**Re: Drainage Memo – Relocate Drop Structure**

This document is the drainage memo for Falcon Ranchettes Filing No. 1a (Meridian Storage). The previously approved Final Drainage Report for this project included a drainage analysis for improvements to the existing roadside ditch along Meridian Road.

**Signature Page**  
**Falcon Ranchettes Filing No. 1a (Meridian Storage)**  
**Drainage Memo – Remove RV Storage**

CHANNEL PLAN & PROFILE

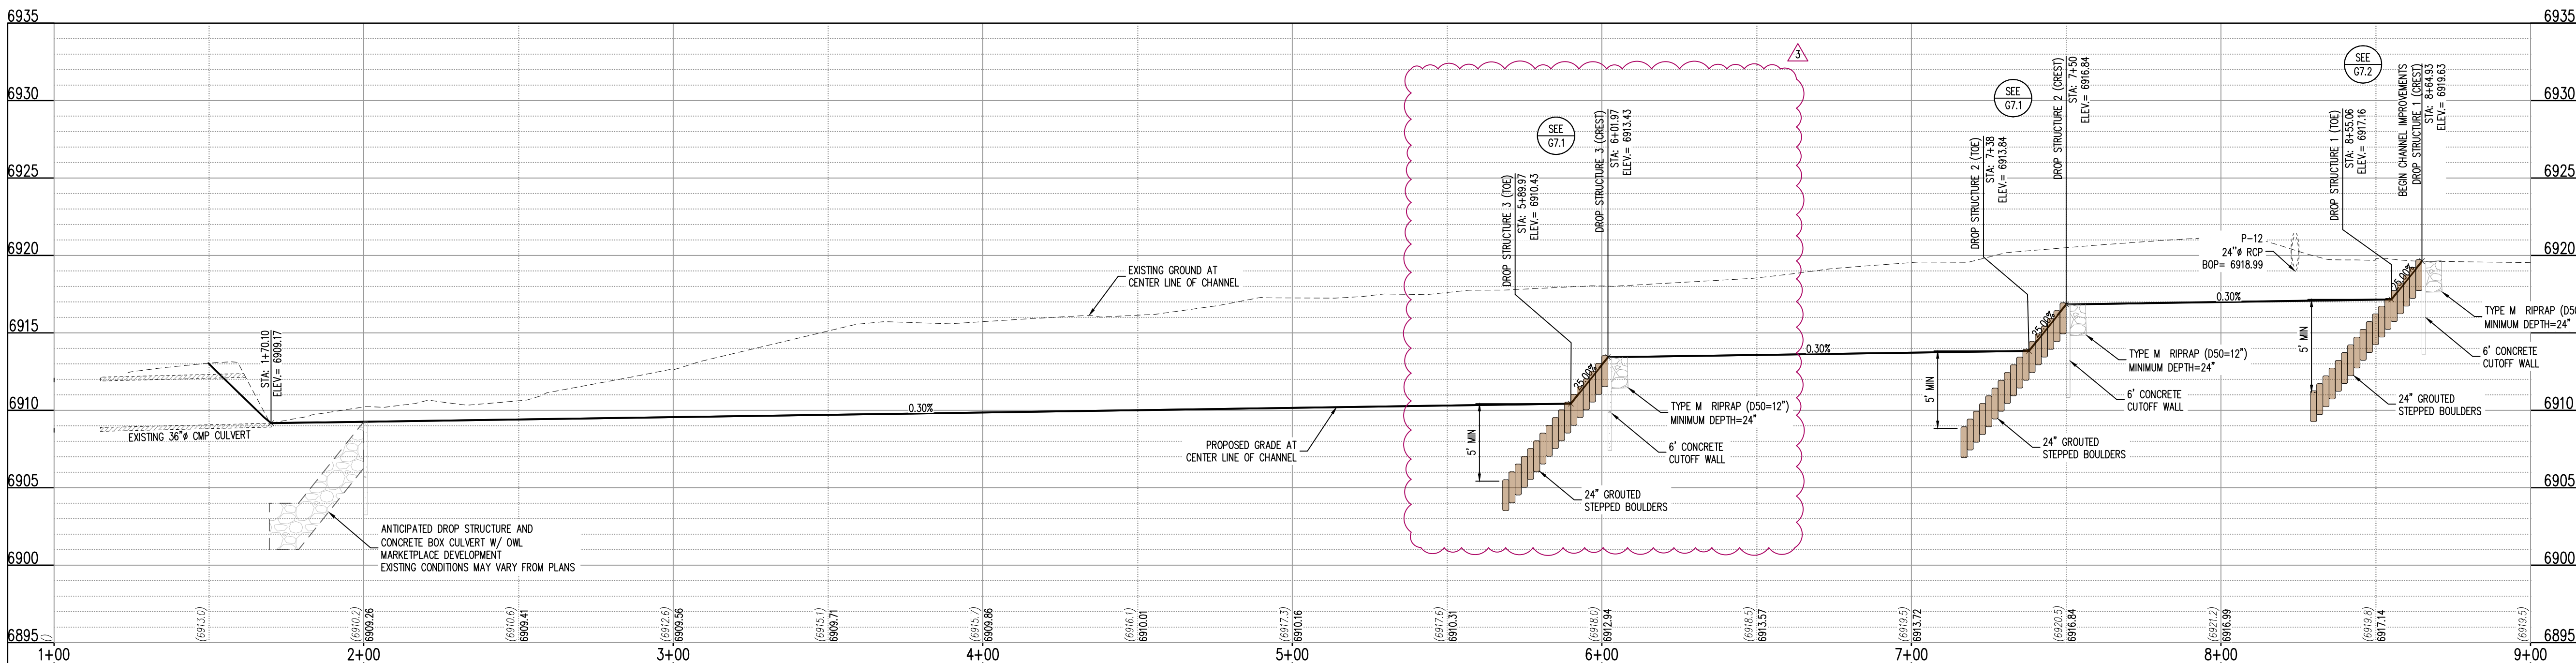
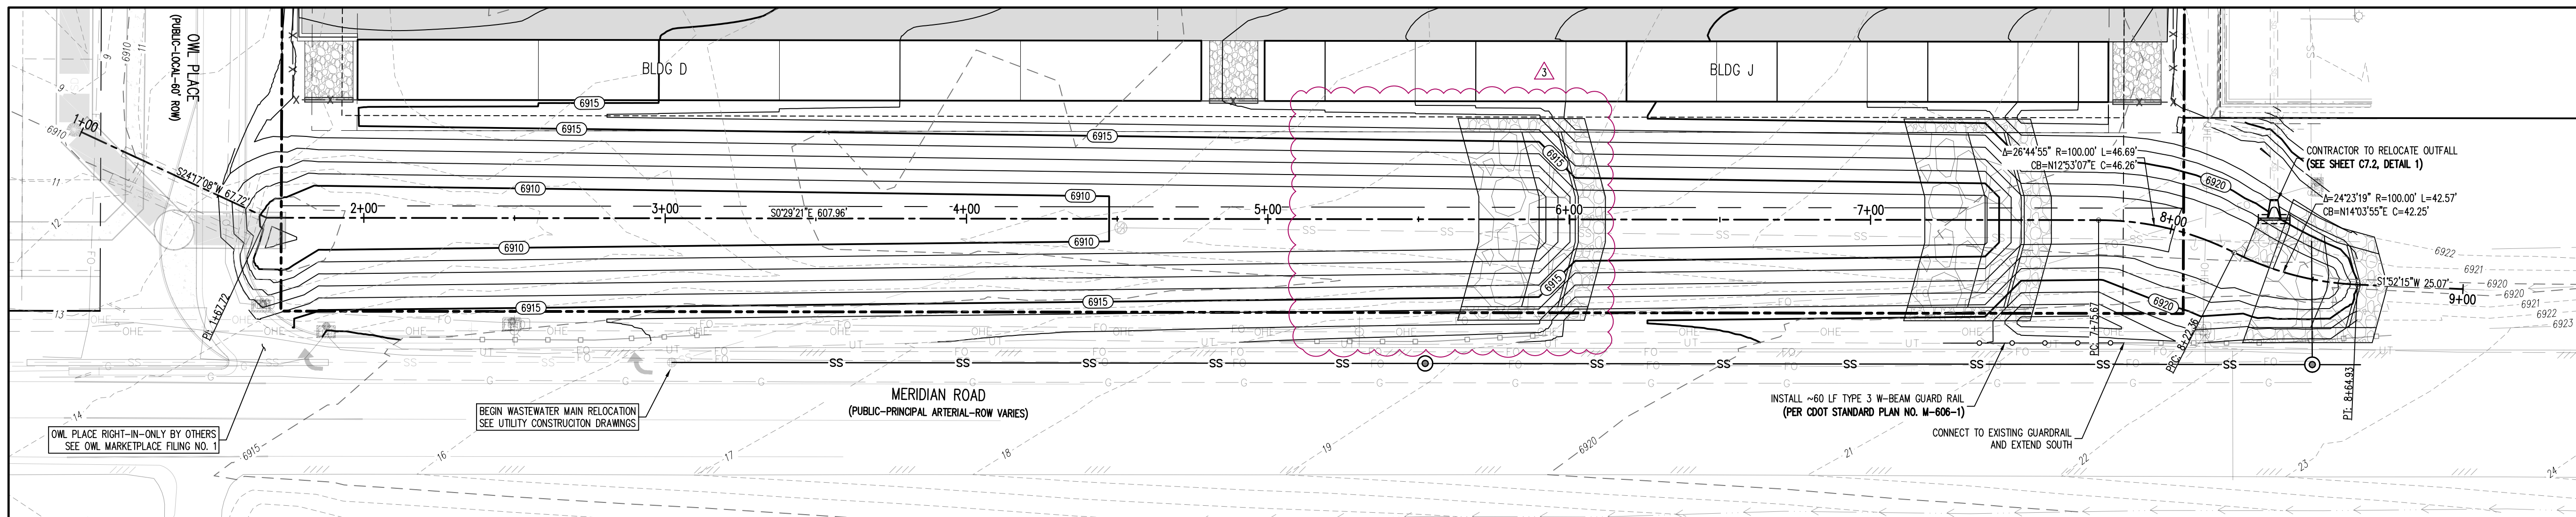
The relocated drop structure (shifted north approximately ~65 LF) imposes no changes to the design parameters nor criteria set forth in the USDCM and approved **FDR**.

Please provide statement that the drainage along the channel will perform as required with respect to the changes made.
